Rezoning Transportation Analysis
Petition Number: Insert Zoning Petition #2021-042
General Location Identifier: 14125107 & 14125108

Revision Log:	Date	Description
	04-29-2021	First Review (KP)
	05-27-2021	Second Review (KP)
	06-30-2021	Third Review (KP)

Transportation Summary

Drawing Title:  
**RZP-2021-042 Conditional  
 Rezoning Site Plan**

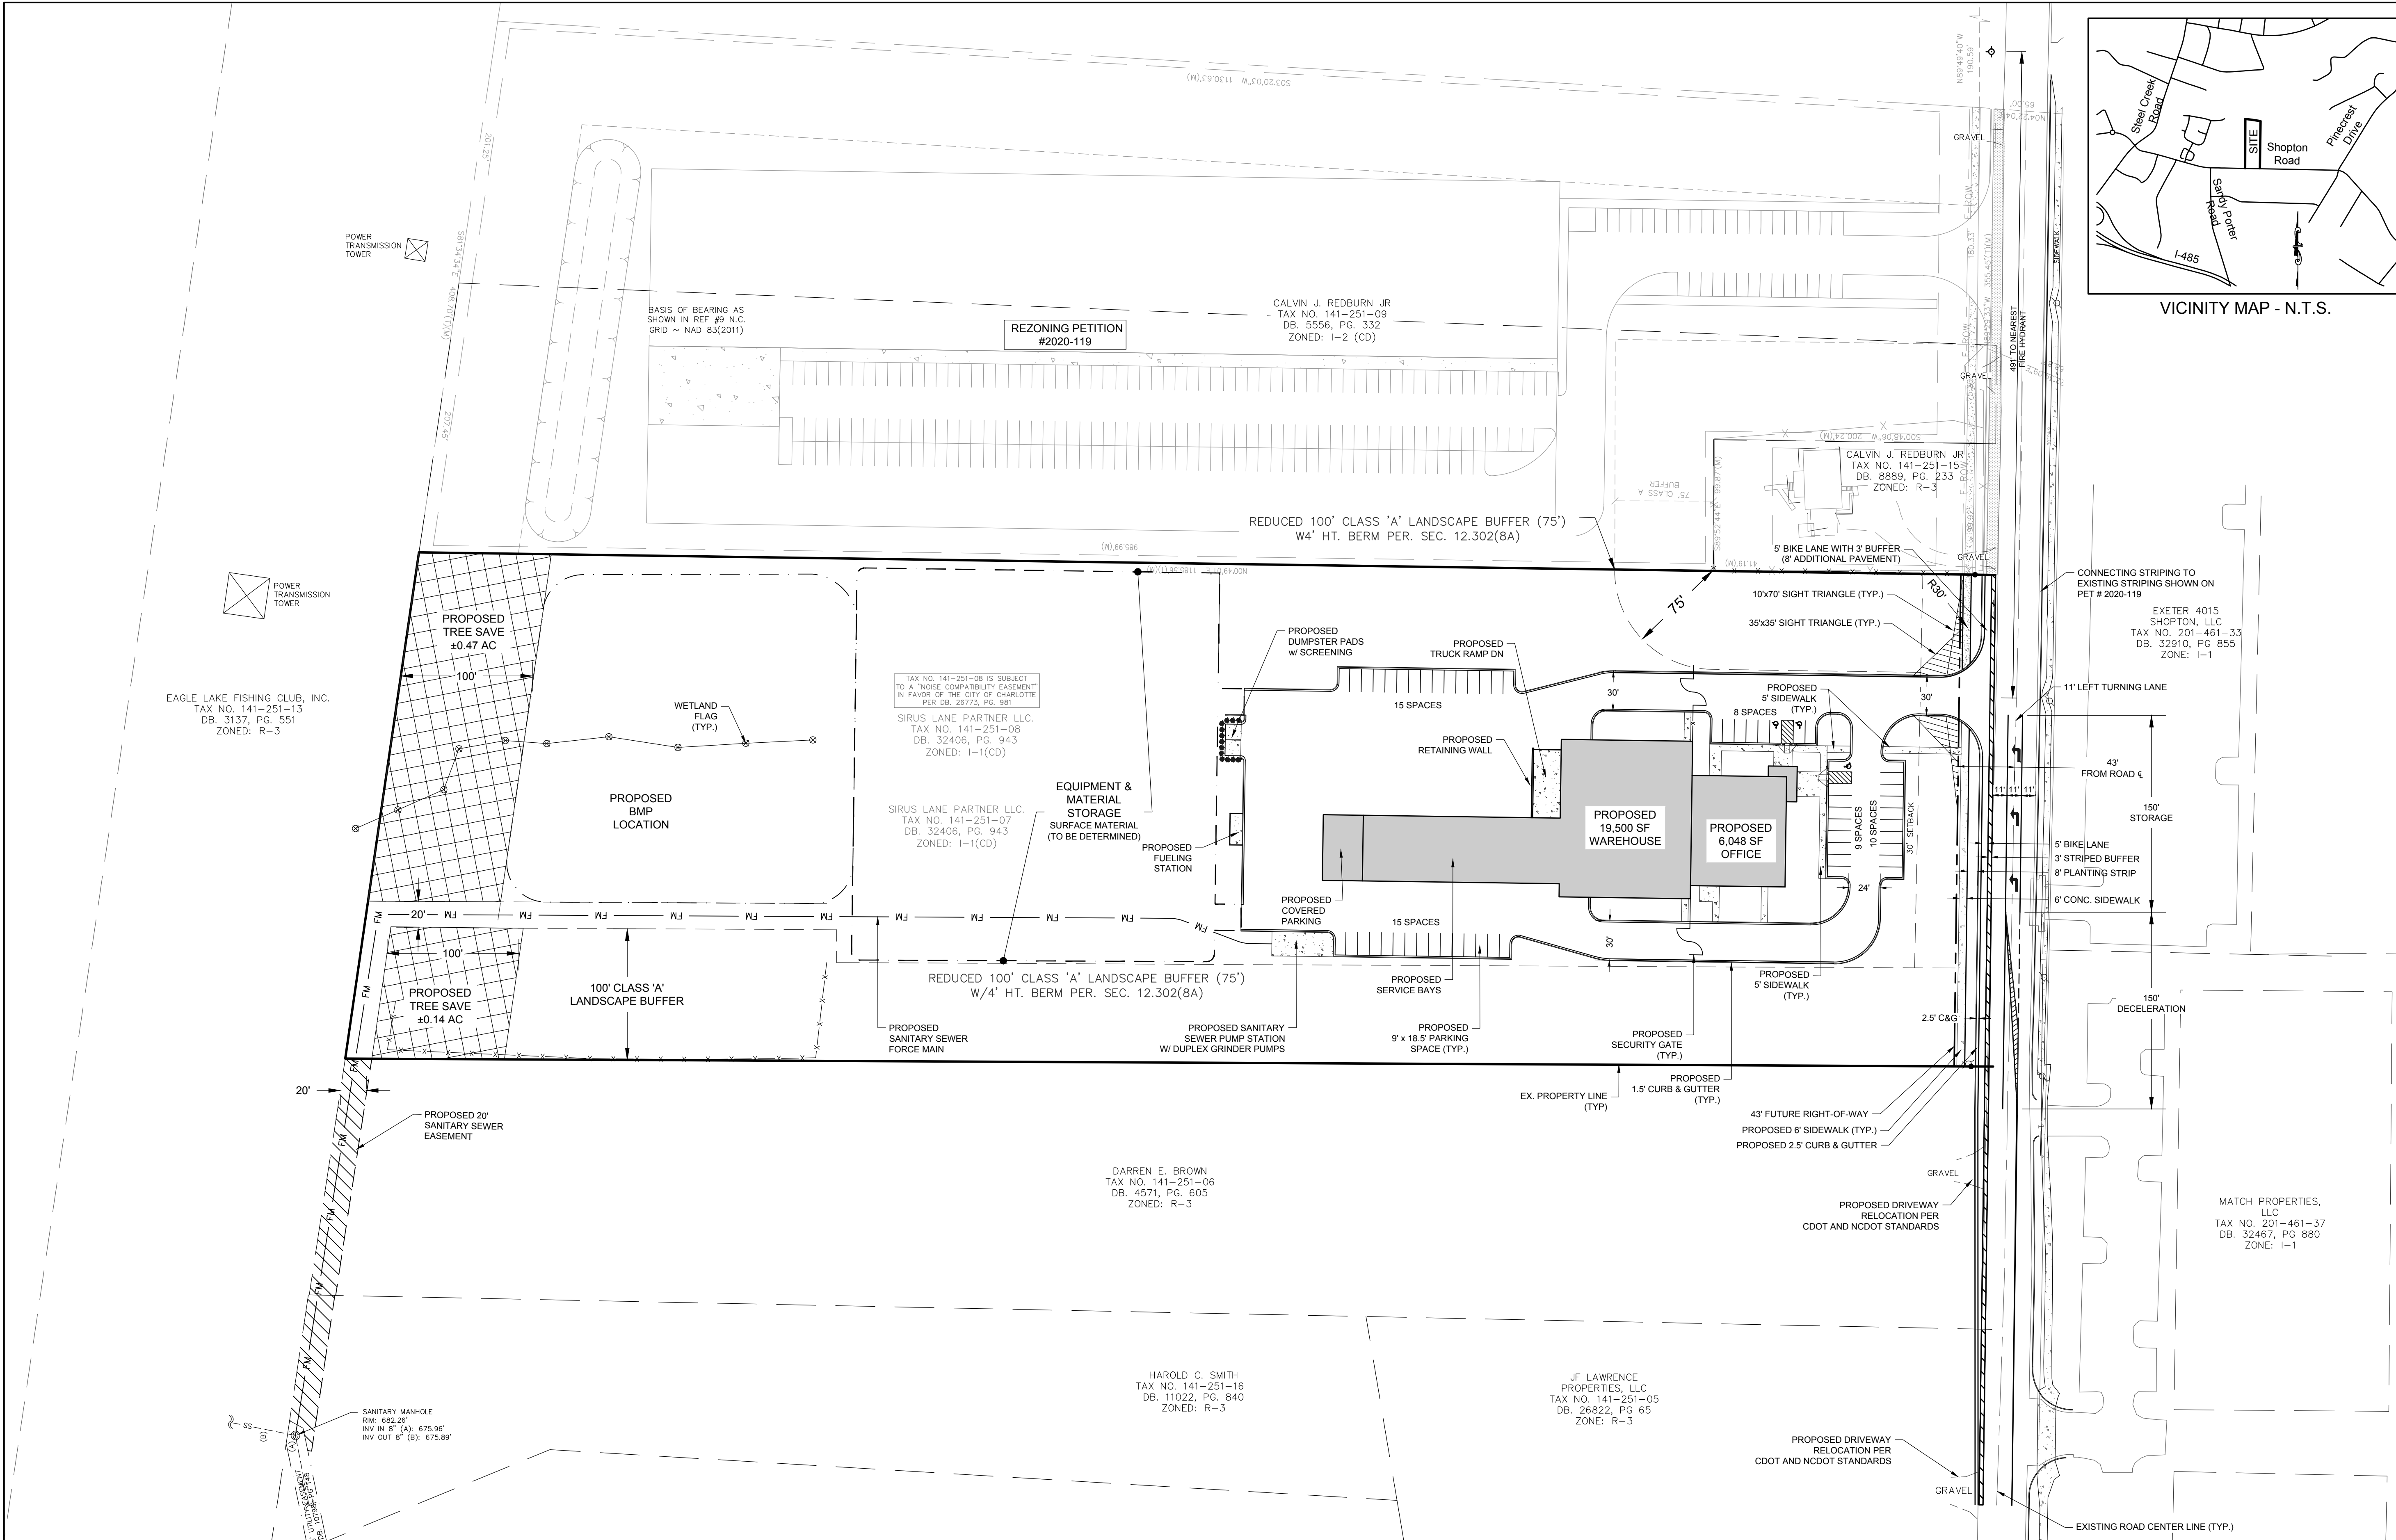
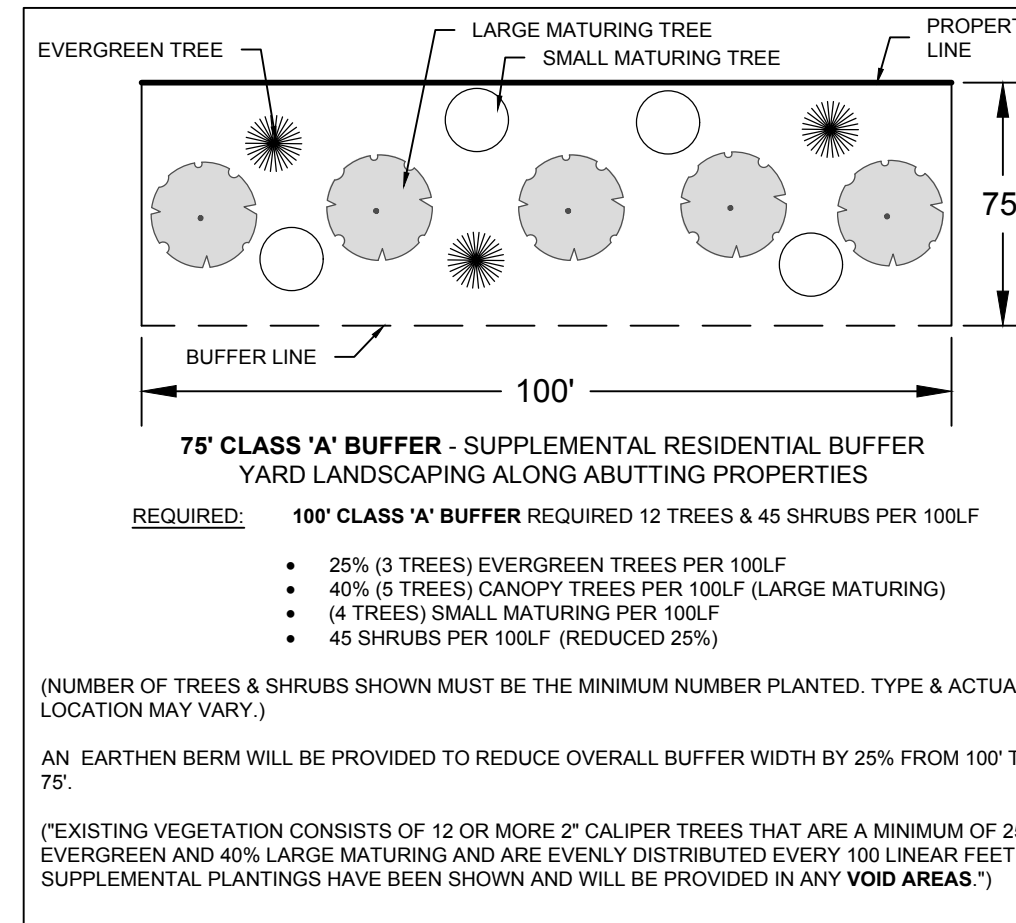
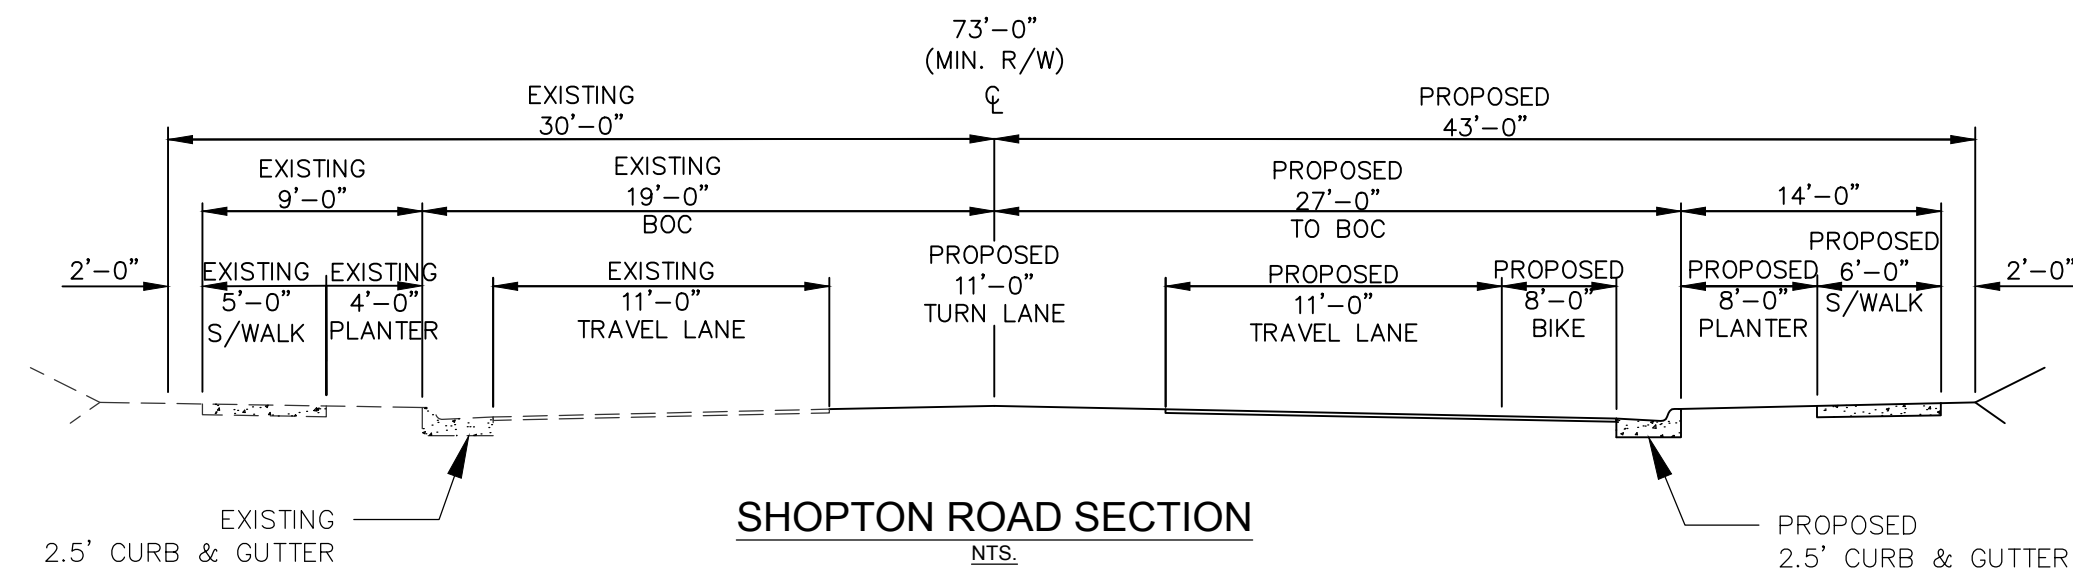
Label and dimension the curb and gutter from the existing road centerline road.
Outstanding Comment from 04-09-2021 Site Plan: Curb line needs to be labeled and dimensioned from the centerline.
